Review #2: MPF

4576 Hennings Dr

Site Plan

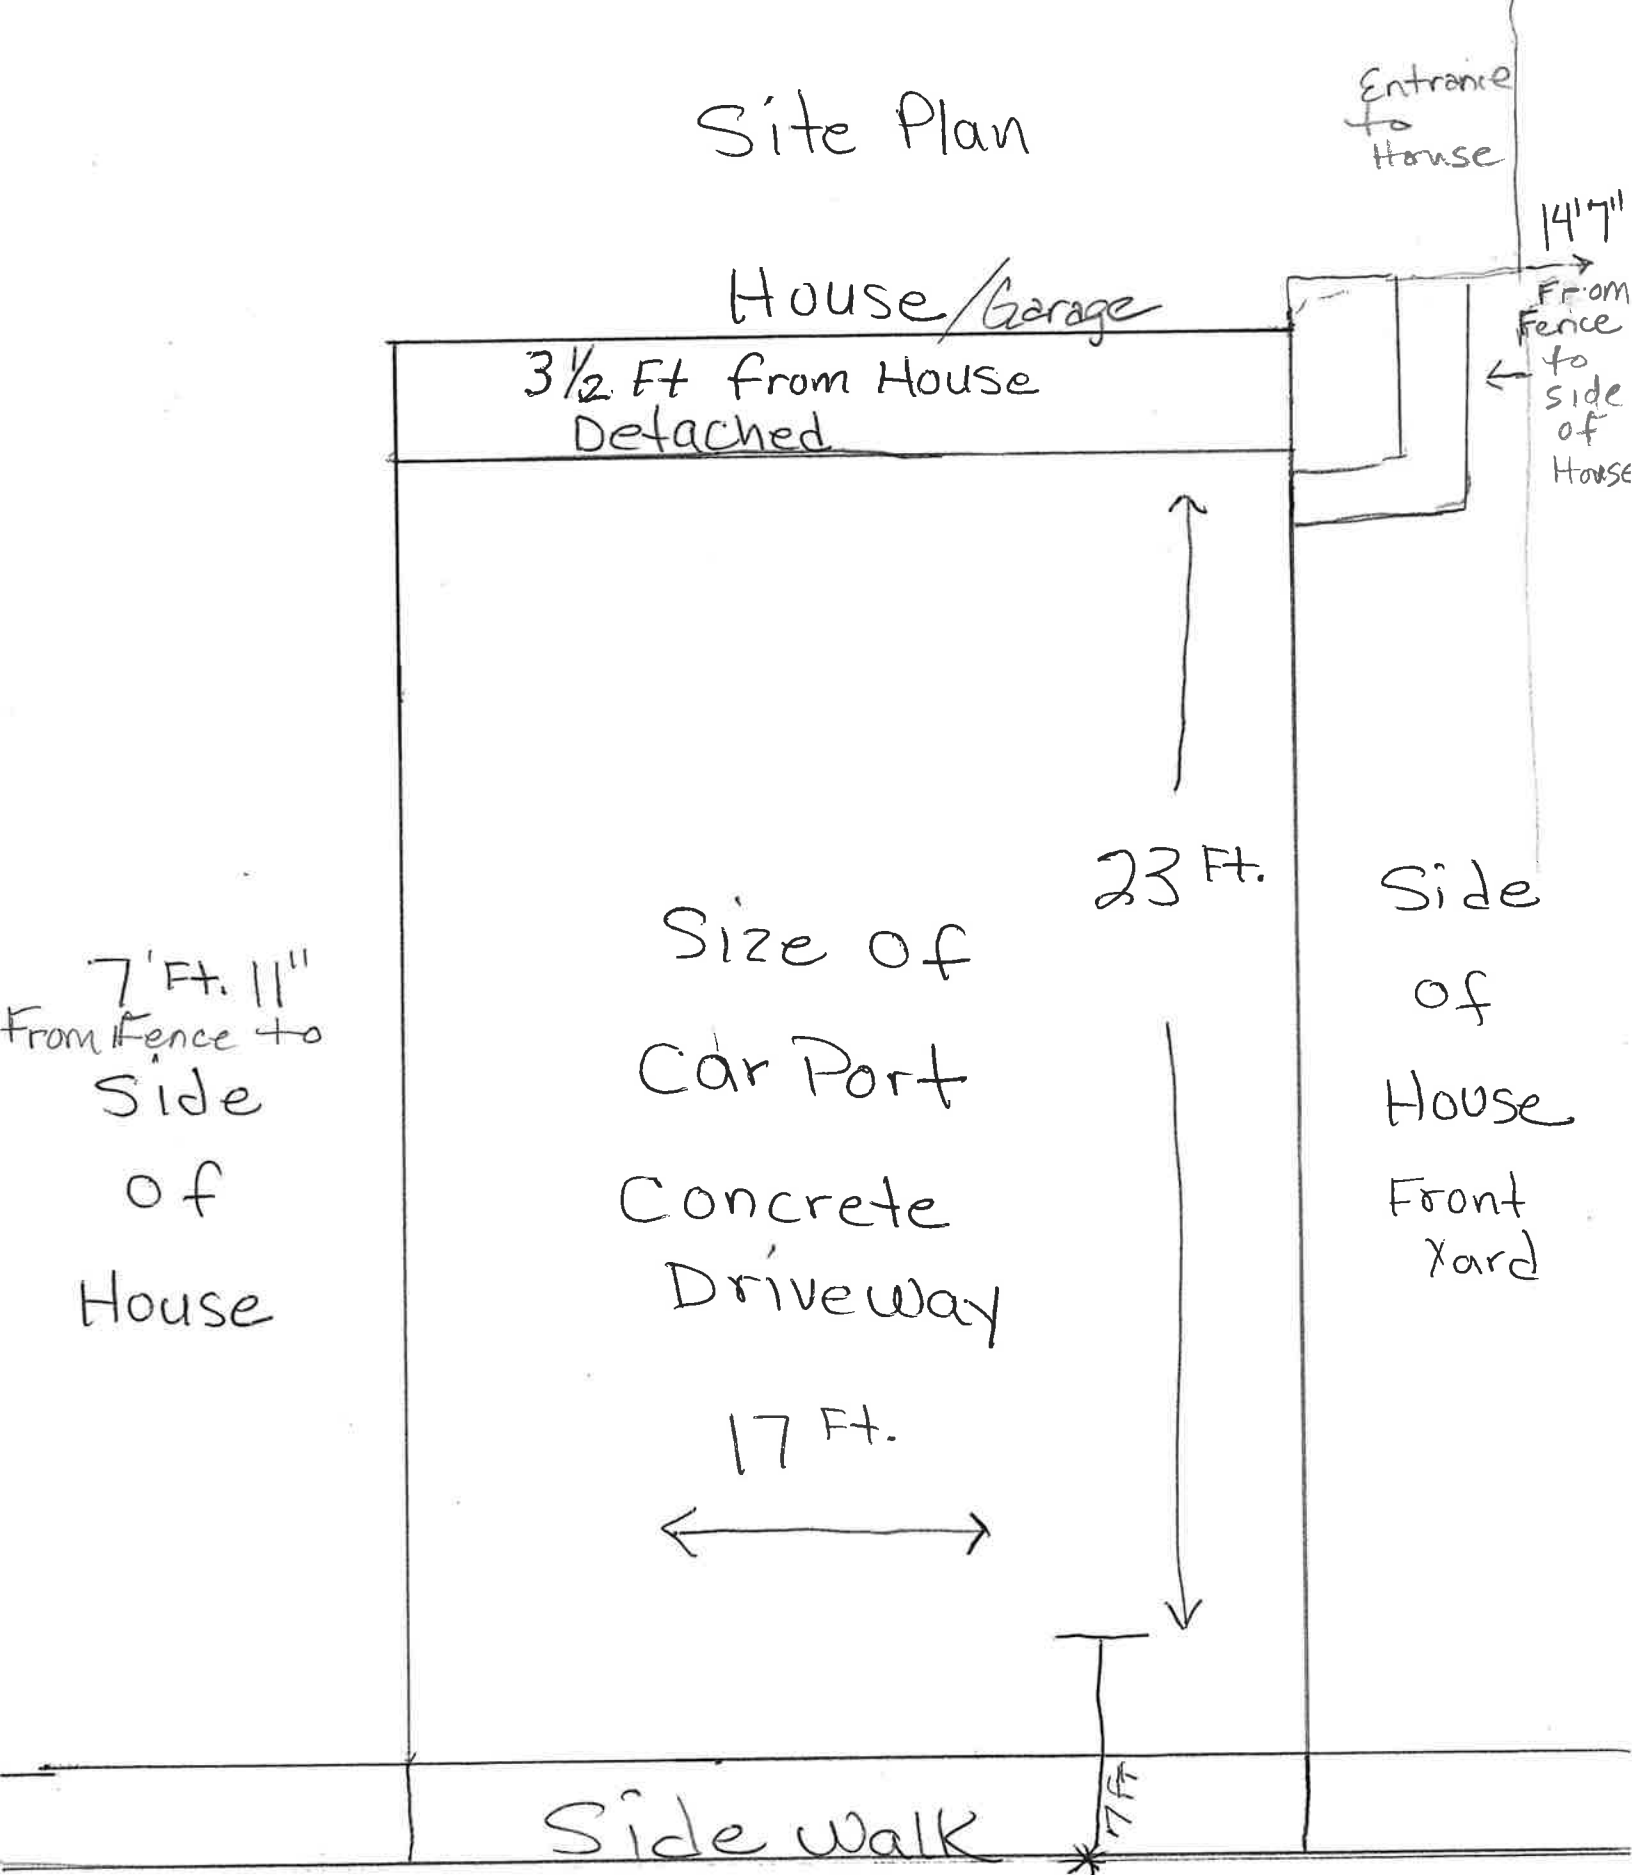
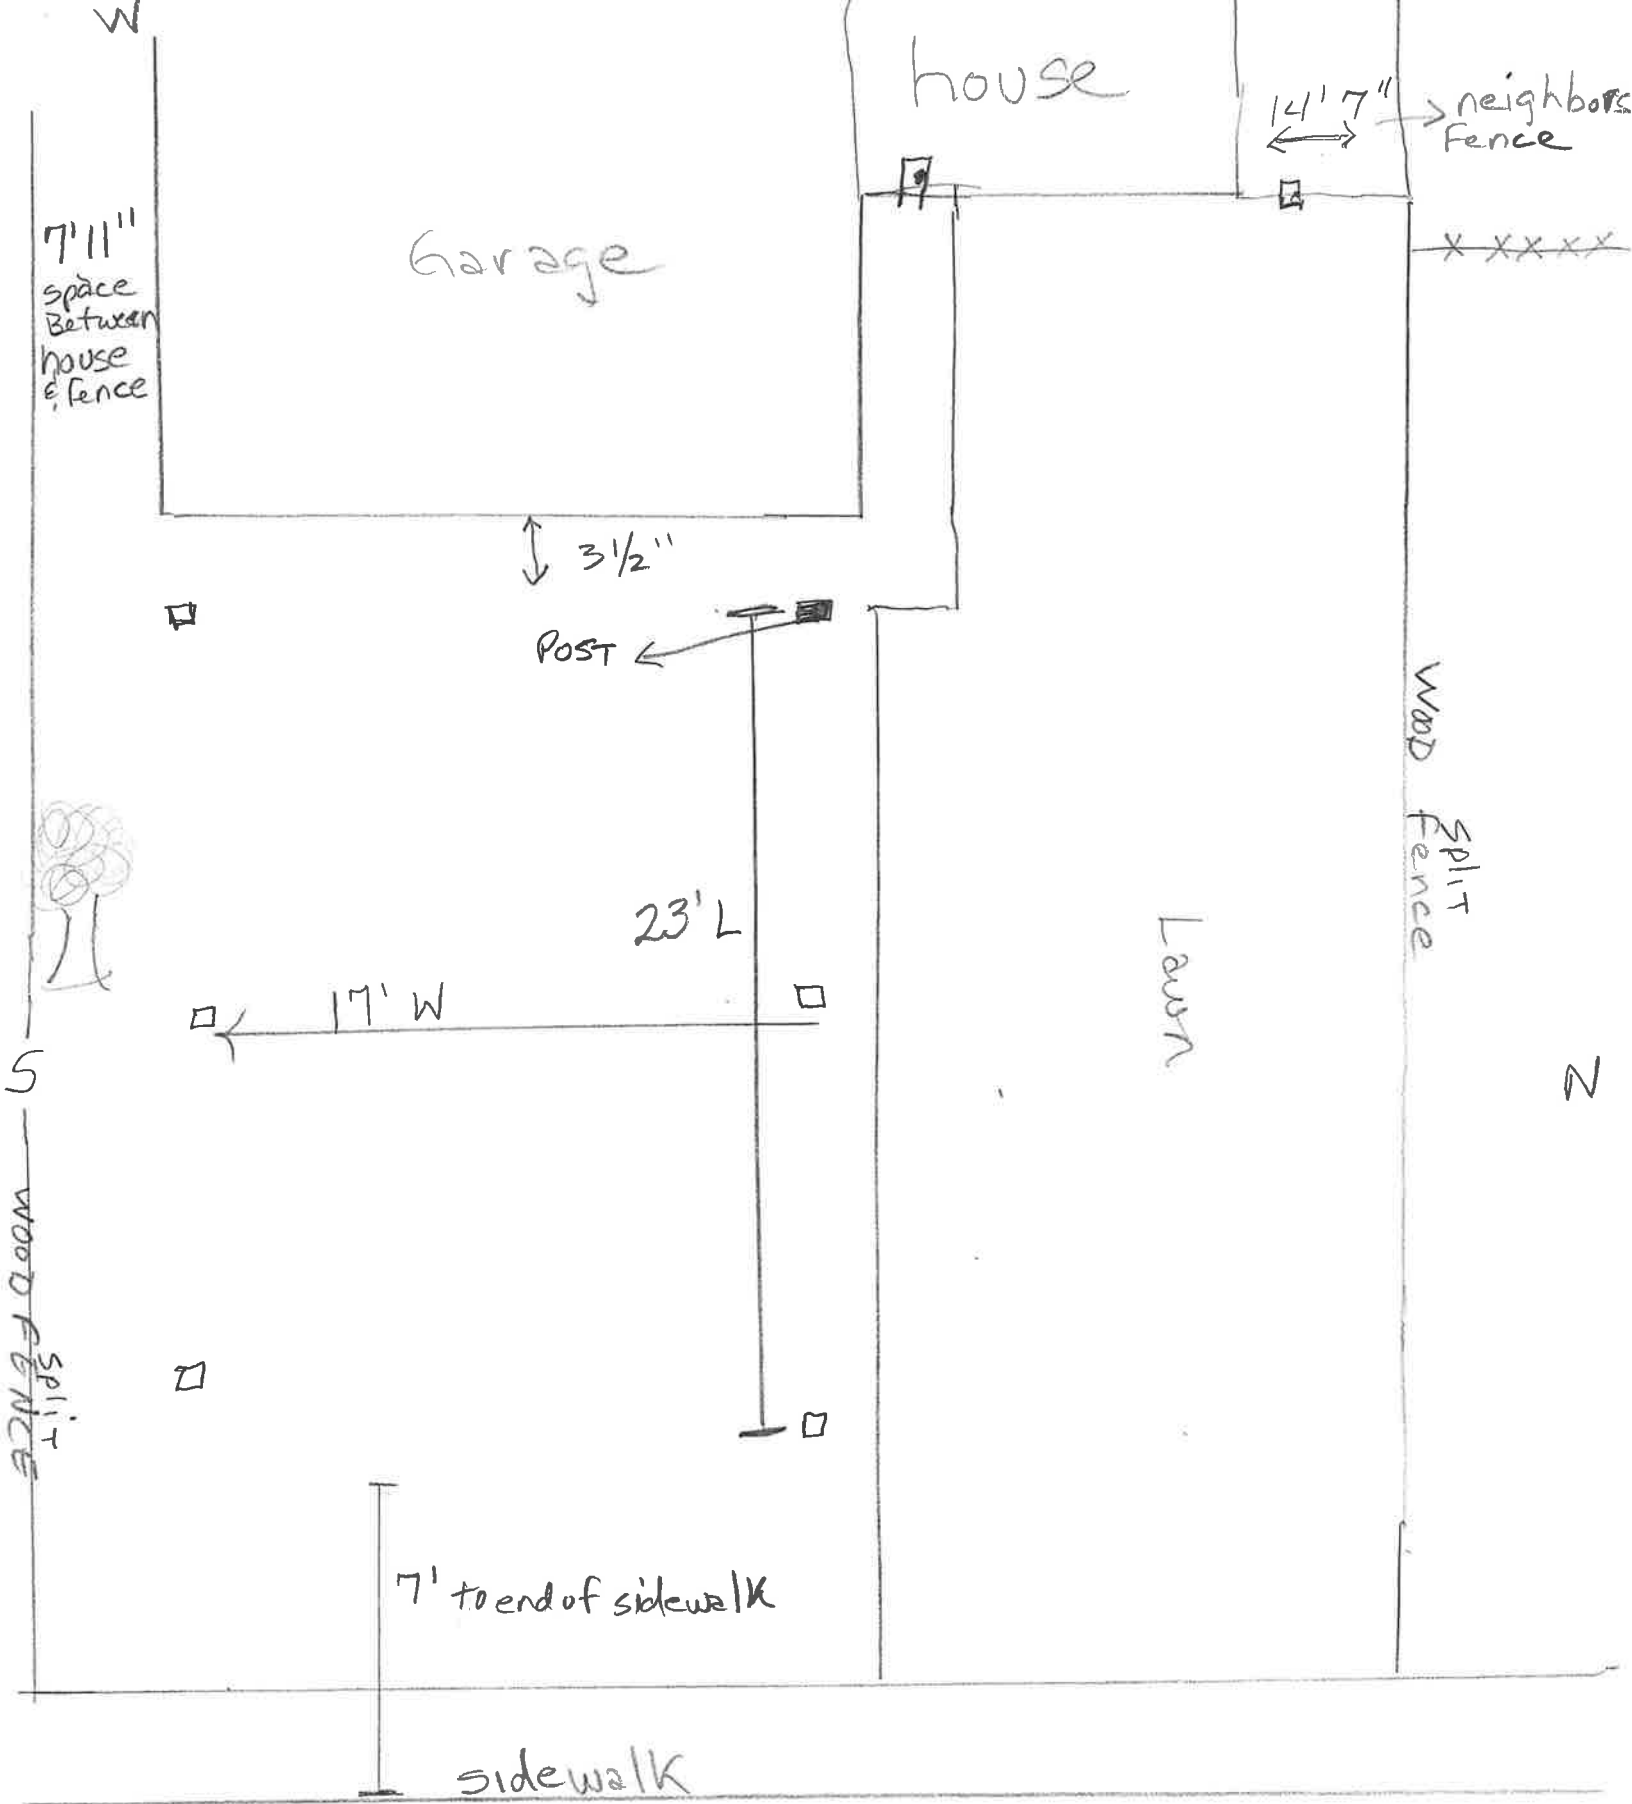
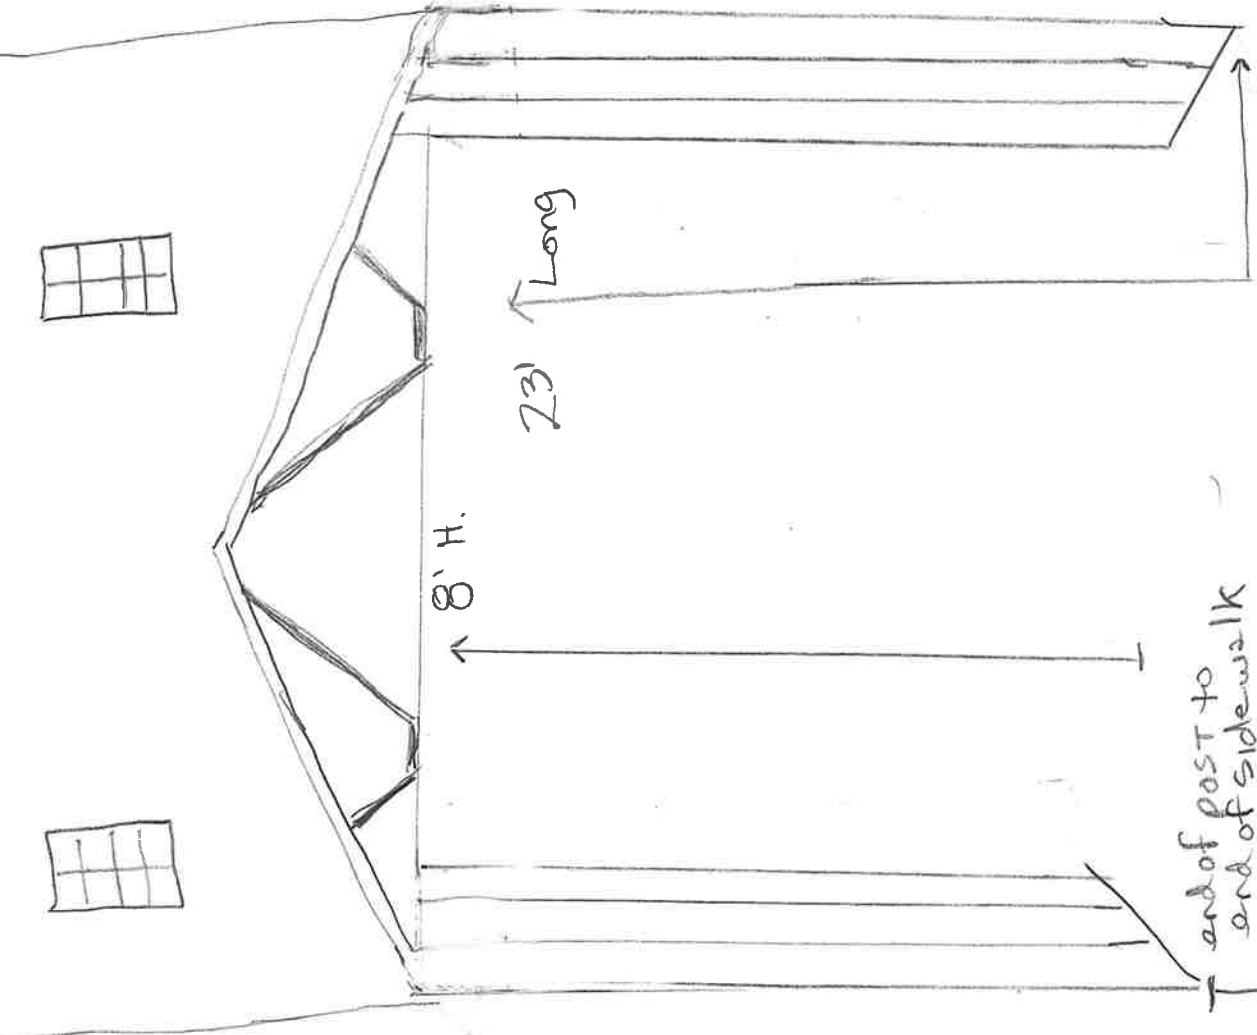
- Include north Arrow on image. it may have been cropped out of the image.
- Indicate where the property line in the drawing. and indicate how close the proposed carport will be from the property line.
- please draw the outline of the carport. it is not clear what is being proposed. Please submit images of what type of carport you are proposing
- please indicate what the "Y", "R" and "red flags" indicate. if they do not support this application, please delete.
- include all dimension to best understand what is being proposed.
- include the name of the applicant, zone, lot size, parcel number, setbacks required and setbacks requested.
